Rixs Creek – (DA 49/94 Mod 9) and Rixs Creek North (DA 08_0102 Mod 7)

Response to Submissions

**Figure 1 Rix's Creek North Approved Project Area**

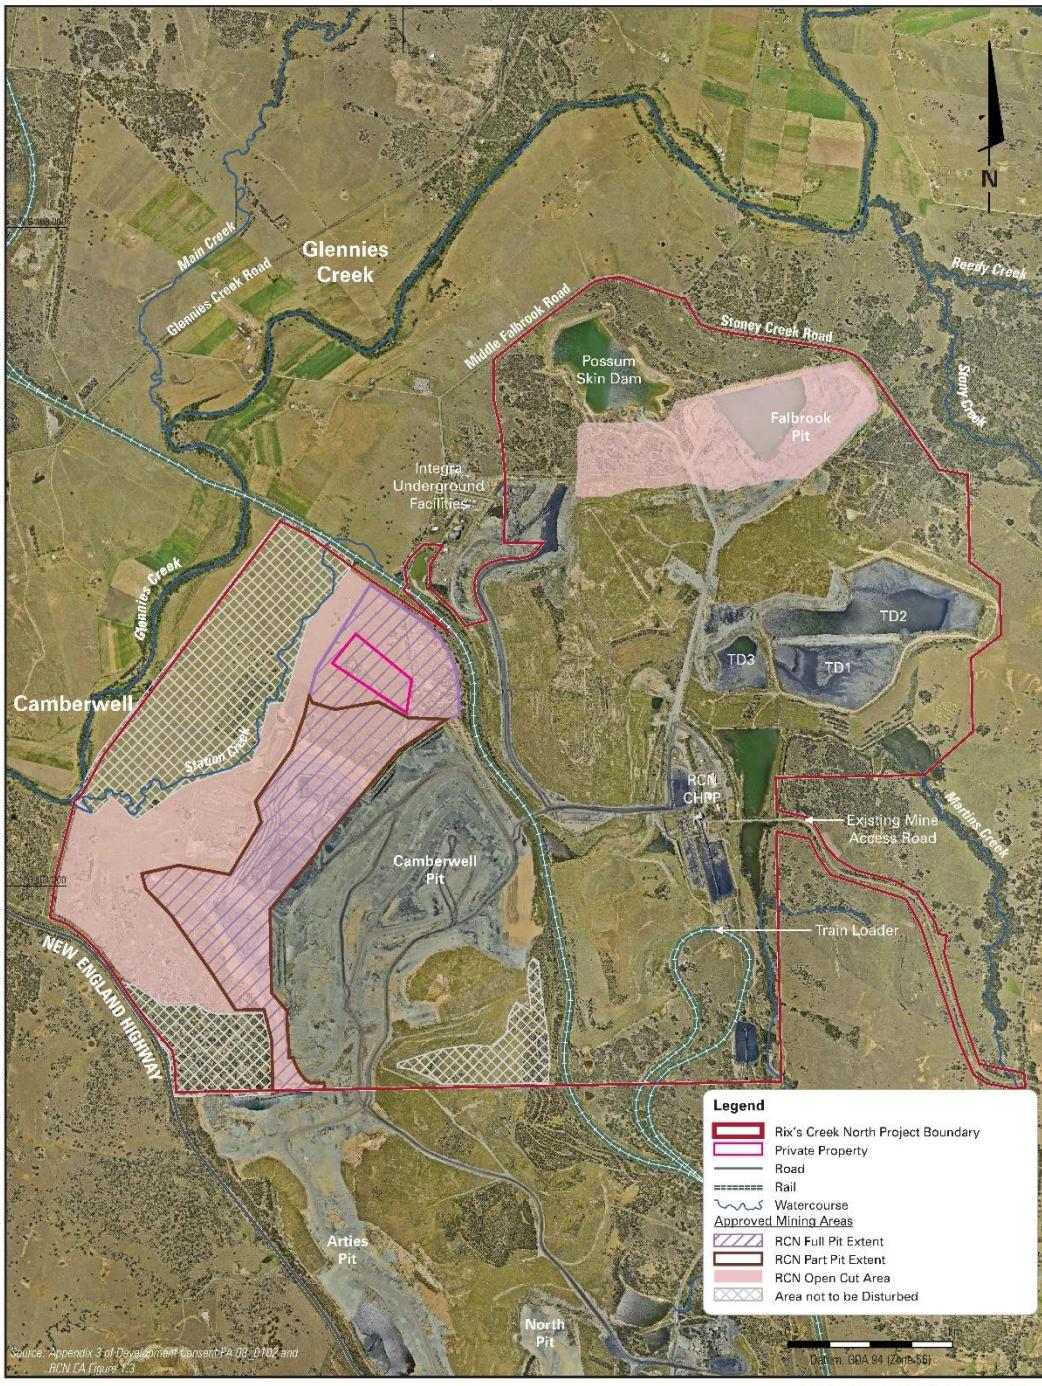
- *“if exploration drilling will occur within the licence boundary or outside of the licence boundary applicable for Rixs Creek Coal Mine (Environmental protection Licence 3391);*
- *How the drilling muds are to be disposed of;*
- *How any ground water make will be re-used or disposed; and*
- *How core material will be disposed of.*

The exploration drilling will wholly occur within the licence boundary applicable to Rixs Creek Coal Mine, Environmental Protection Licence (EPL) 3391. The attached figures 1 and 2 demonstrate this.
